From: June Grinstead [REDACTED]
Sent: 10 April 2019 16:26
To: Zac Denton
Subject: Re: M/19/19/HH : 74 Priestley Way

Proposed Elevations

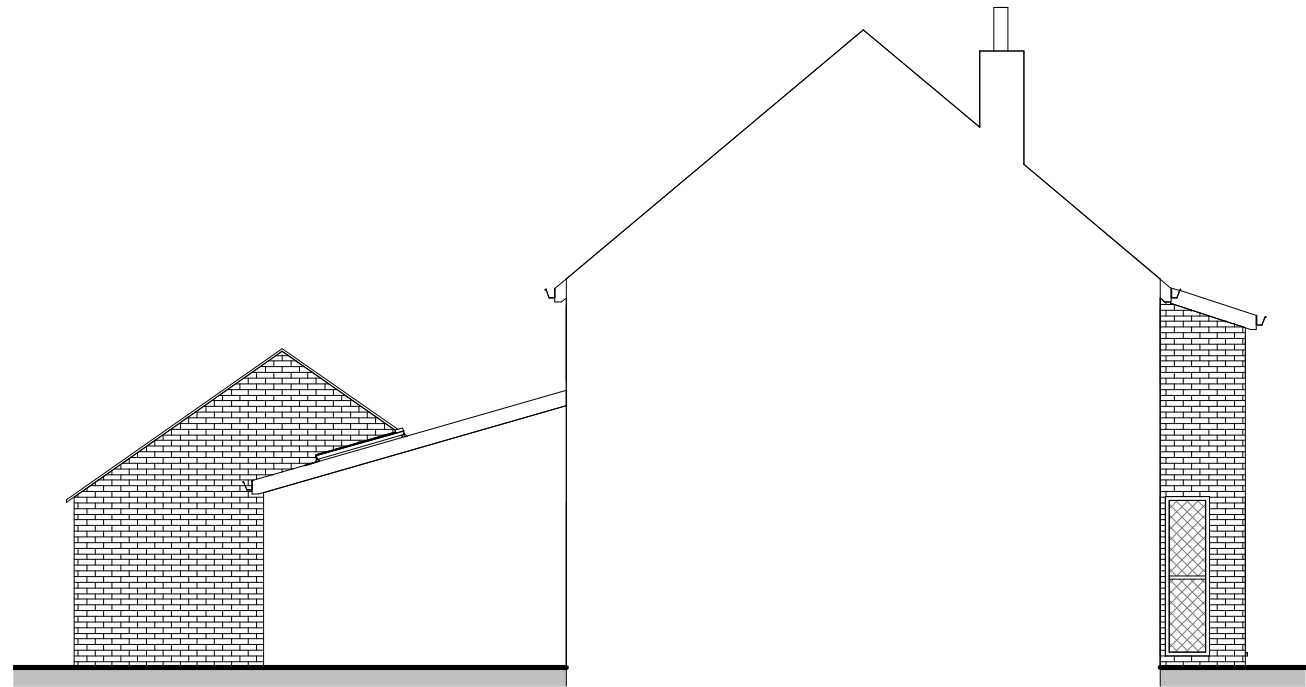
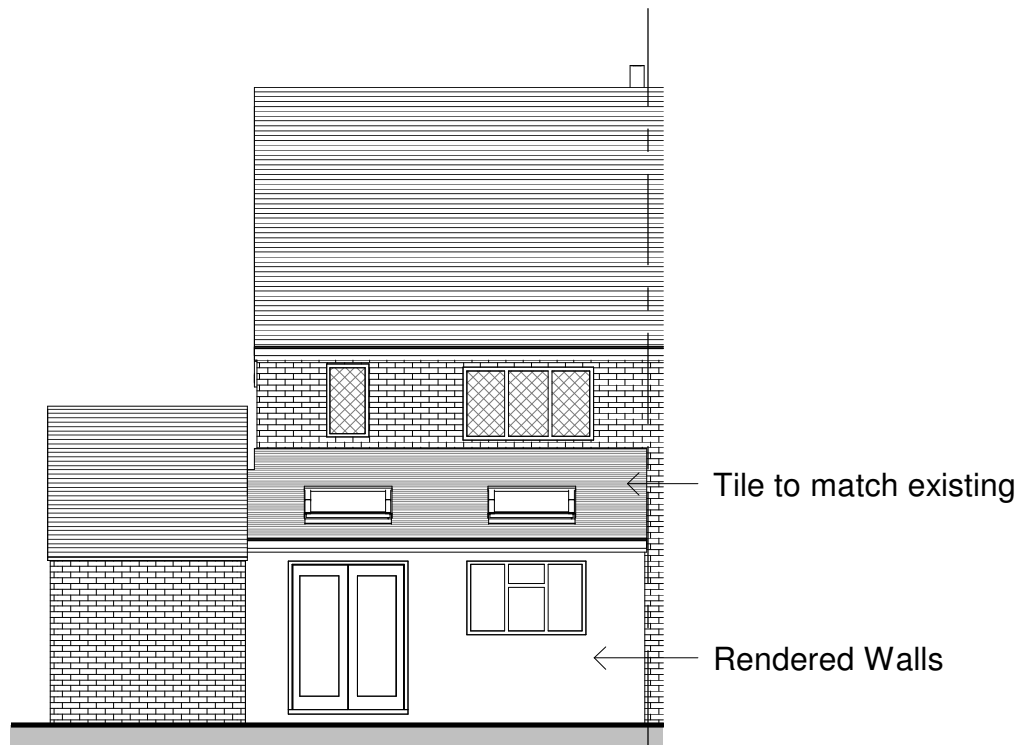
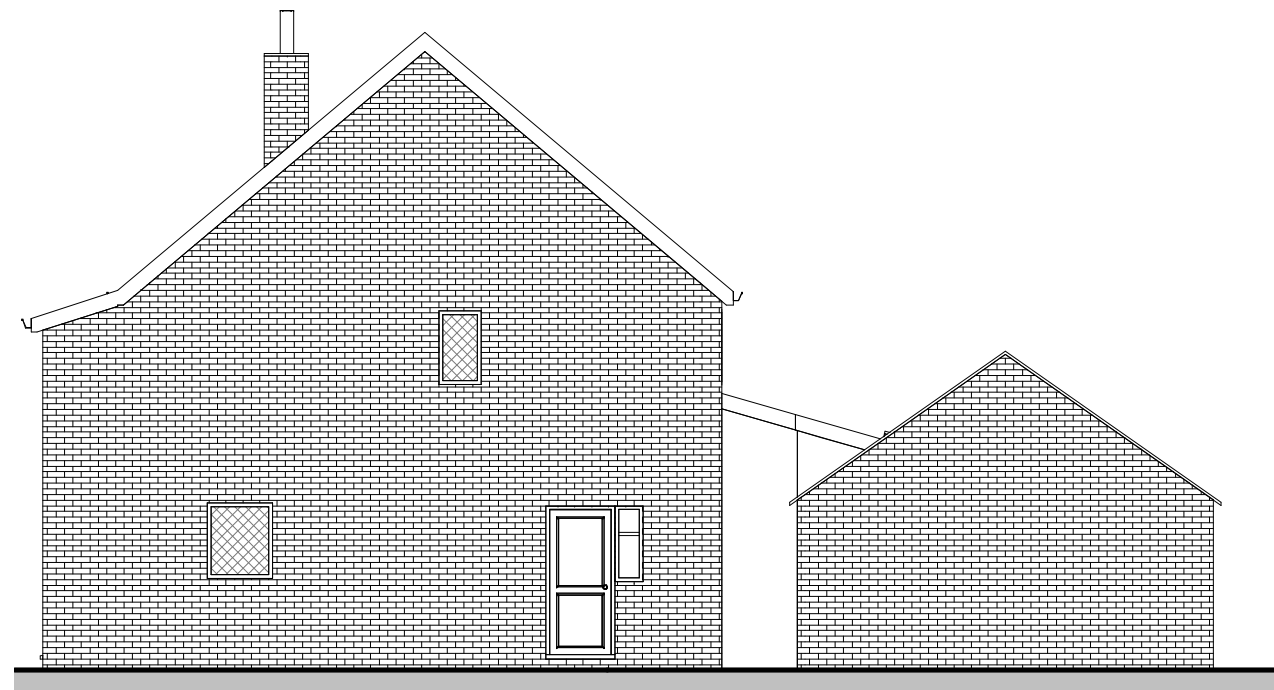
I do not have any outright objections to the application at current. Are you able to confirm some details of the materials?

Are the proposed tiles to match?

What colour is the proposed render?

What colour is the framing of the proposed fenestration?

The roof tiles are to match existing. Render is to be White and windows to match existing which is brown.
